Recommendation Report for Listed Building Consent for Alterations, Extension or Demolition of a
Listed Building

REF NO: BN/96/19/L

LOCATION: Barnham Court
Church Lane
Barnham
PO22 0BP

PROPOSAL: Listed building consent for the removal of collapsed West greenhouse & planned removal of unsafe South greenhouse; replaced with orangeries in style of Anglo Dutch design & 17th century vernacular.

| Title                                                                                                                         | West Orangery Proposed |

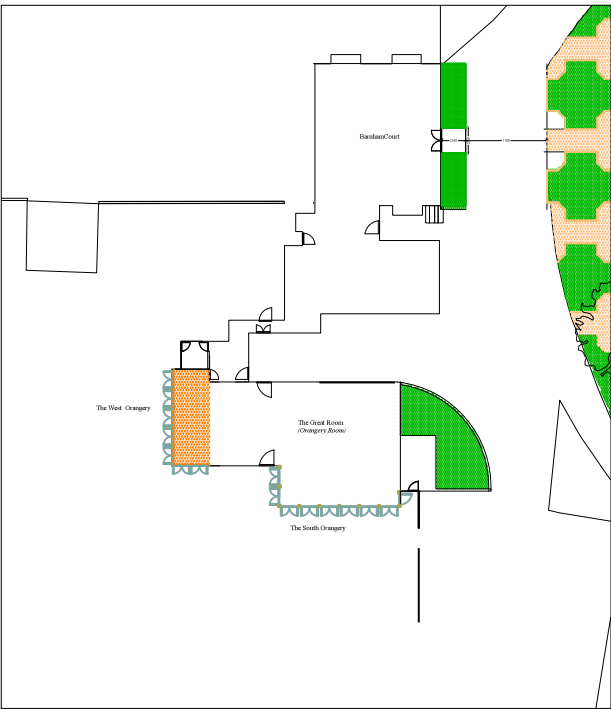
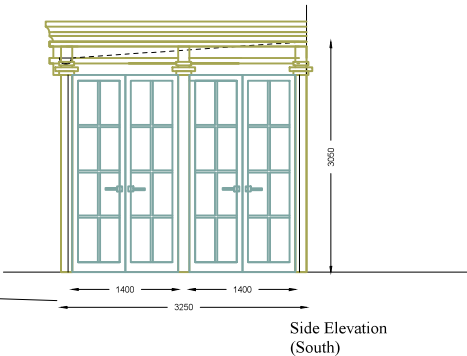
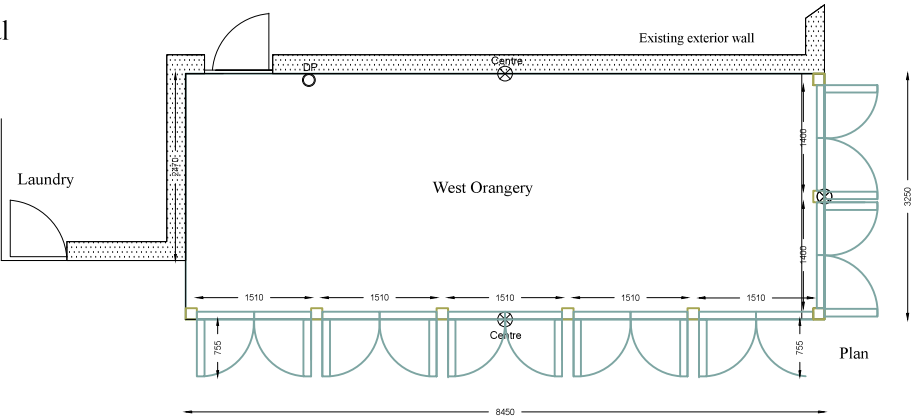
It is not clear how the western orangery will join up to the existing single storey laundry structure, especially with regards to the existing roof structure and associated rainwater goods. Details of this junction should be provided to the council at an appropriate scale.

It is also noted that the proposed plans indicate a new door opening from the existing garage/service building into the western orangery. However, it is not clear if this opening currently existing or not.

Detailed drawings of all the joinery including the doors and oak timber posts with Doric columns should also be provided along with details of the proposed colour. Whilst this might be the same as existing elsewhere, it would help to have the actual colour name/reference no. on file. Drawings should be provided at an appropriate scale and provide details of the glazing/glazing bars.

- 3 No development shall commence until detailed drawings showing how the western orangery will join up to the existing single storey laundry structure, especially with regards to the existing roof structure and associated rainwater goods, have been submitted to and approved by the Local Planning Authority. Details of this junction should be provided at the scale of 1:20.

- 4 No development shall commence until detailed drawings of all the joinery including the doors and oak timber posts with Doric columns and a new door from the opening from the existing garage/service building into the western orangery along with details of the proposed colour have been submitted to and approved by the Local Planning Authority. Drawings should be provided at an appropriate scale and provide details of the glazing/glazing bars.
